Blacktown Mt Druitt Hospital: Blacktown Hospital Stage 1 Expansion (SSD5263)

Thank you for your letter dated 3 September 2012 in regards to your request for comment on the proposed application (SSD 5263). Transport for New South Wales (TfNSW) provides the following comments to the above project application:

Attachment 5 – TfNSW requested pedestrian access improvements

Figure 2 Internal Bus Loop

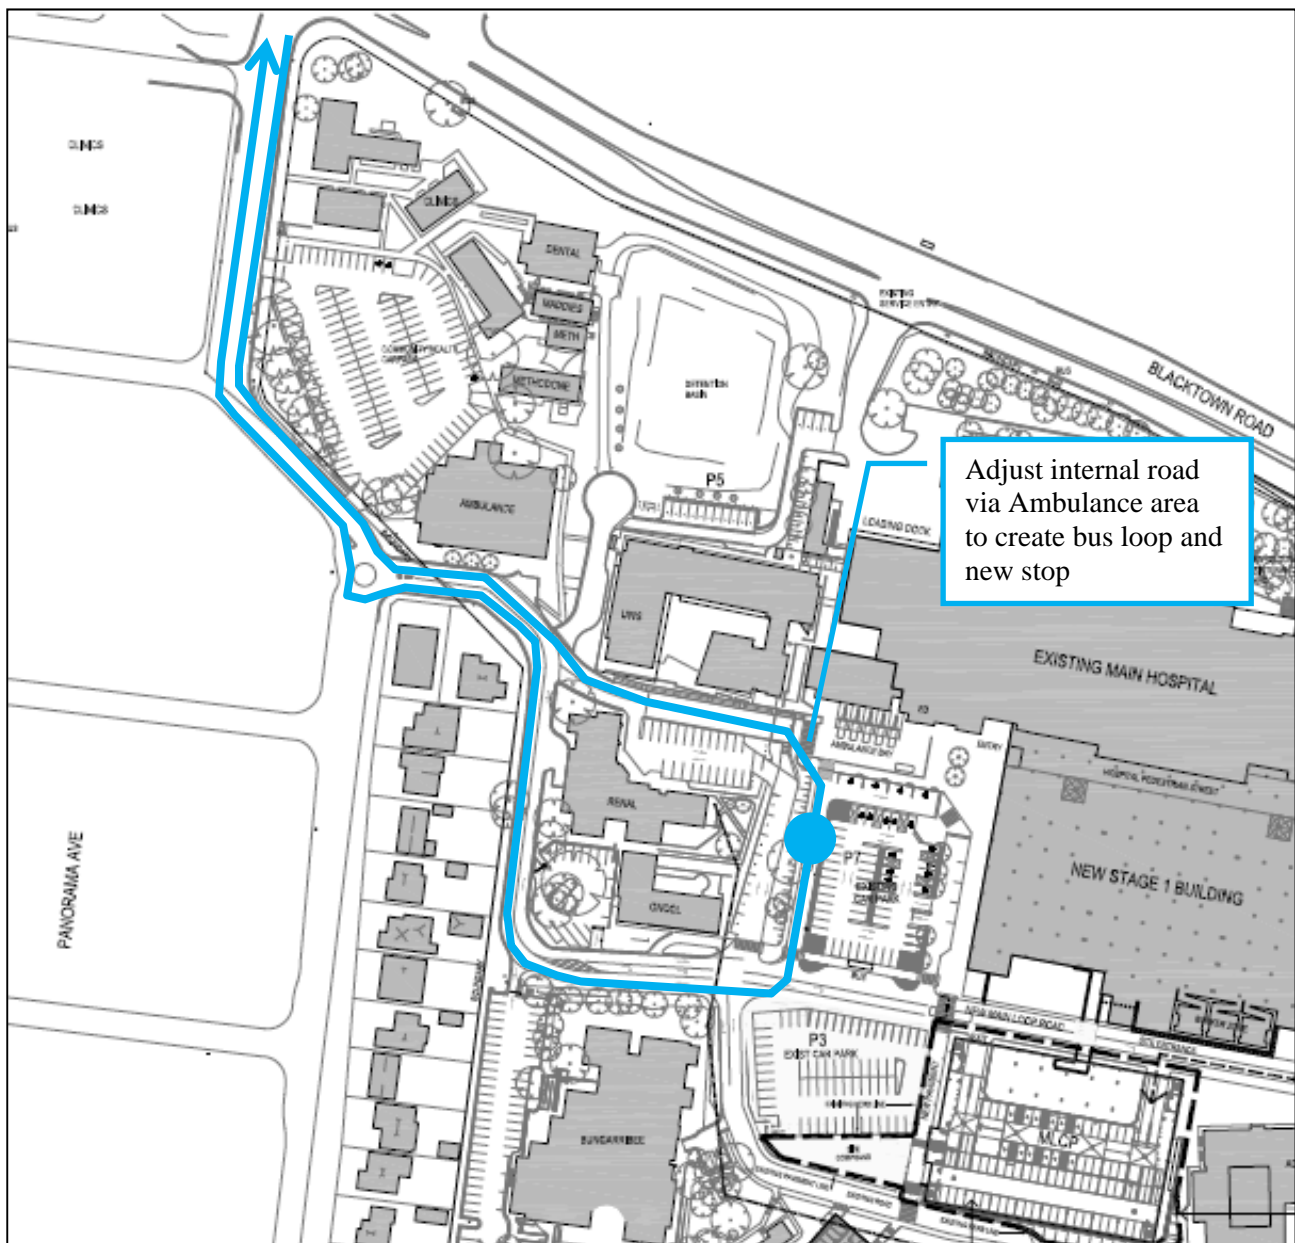
- The configuration of the internal roadways will add to travel times for Route 721 buses serving the Hospital, impacting on journey times for passengers and increasing on-going operational costs to Government. Future bus routes will be restricted in how they will be able to service the site as all buses entering the site must subsequently exit westwards along Blacktown Road. While this does not present an issue for the current (temporary) free Blacktown CBD shuttle bus, the site layout will permanently impact on the costs associated with servicing the hospital by regular route buses linking the hospital to other areas.

TfNSW would prefer that buses have the opportunity to turn on site, entering and exiting via Panorama Avenue and Marcel Crescent which allows the flexibility of left and right turn movements out onto Blacktown Road. TfNSW would like to discuss this servicing matter with the proponent.

Figure 3 Pedestrian Access from Blacktown Road

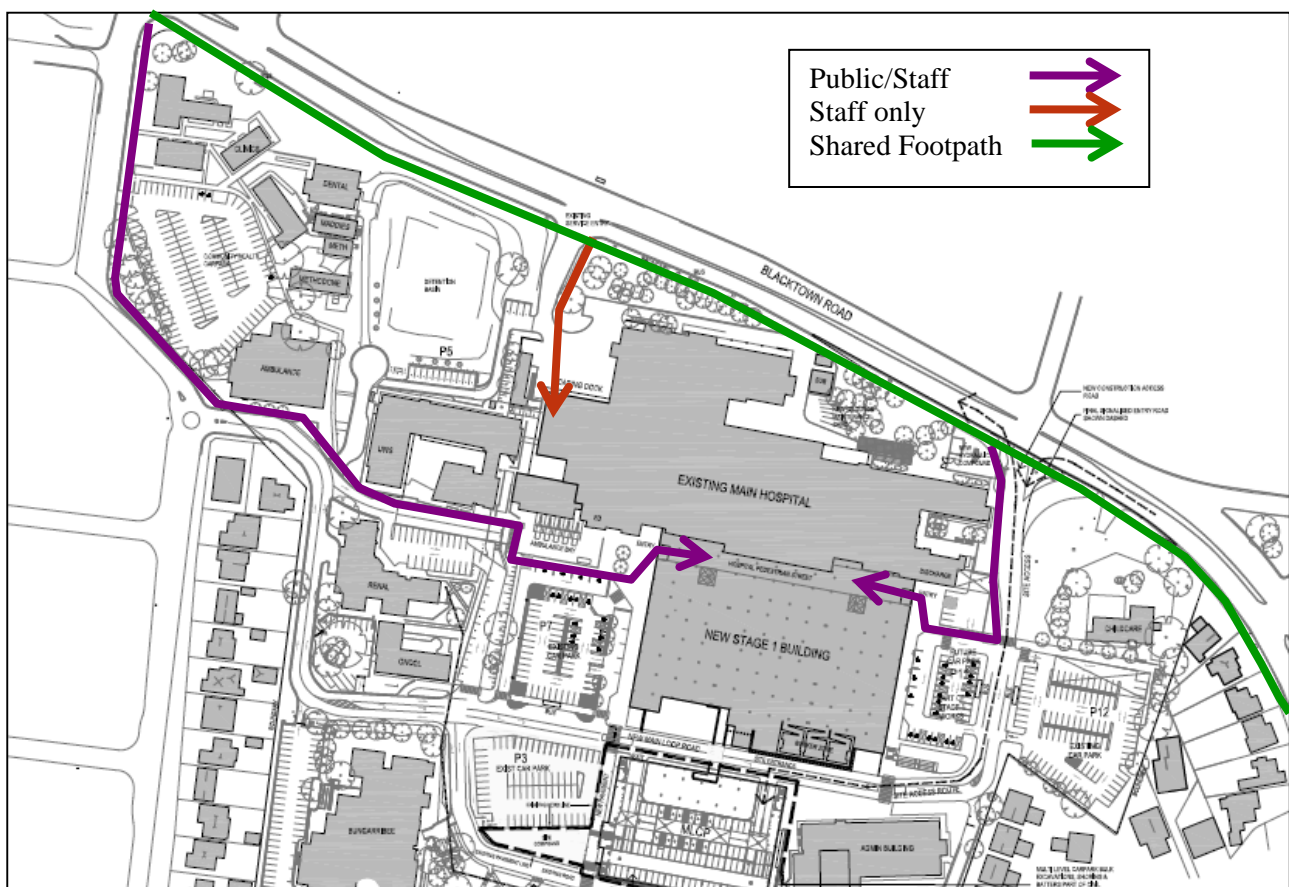
- The Transport and Accessibility Study identifies poor pedestrian access conditions on Blacktown Road and poor access to the Hospital from the east due to the lack of a pedestrian crossing at the intersection with Wall Park Avenue. The Study fails to meet the EIS requirements in addressing these inadequacies in the immediate vicinity of this development, being a major public health facility in Western Sydney.

- Transport for NSW recommends the following improvements be undertaken by the proponent to improve pedestrian access to bus services (Attachment C):
 - the provision of a sheltered accessible bus stop in the vicinity of the signalised intersection of Blacktown Road and Marcel Crescent, helping to minimise walking distances for hospital patients, staff and visitors

- the relocation of the existing bus stop fronting the Hospital site on Blacktown Road near the intersection of Blacktown Road and Marcel Crescent, closer to this intersection to minimise walking distances. This bus stop should be sheltered

- the provision of direct pedestrian access to the main entrances of the Hospital buildings from the existing bus stop fronting the Hospital site near the Hospital's service entry off Blacktown Road, helping to minimise walking distances. This bus stop should also be sheltered.
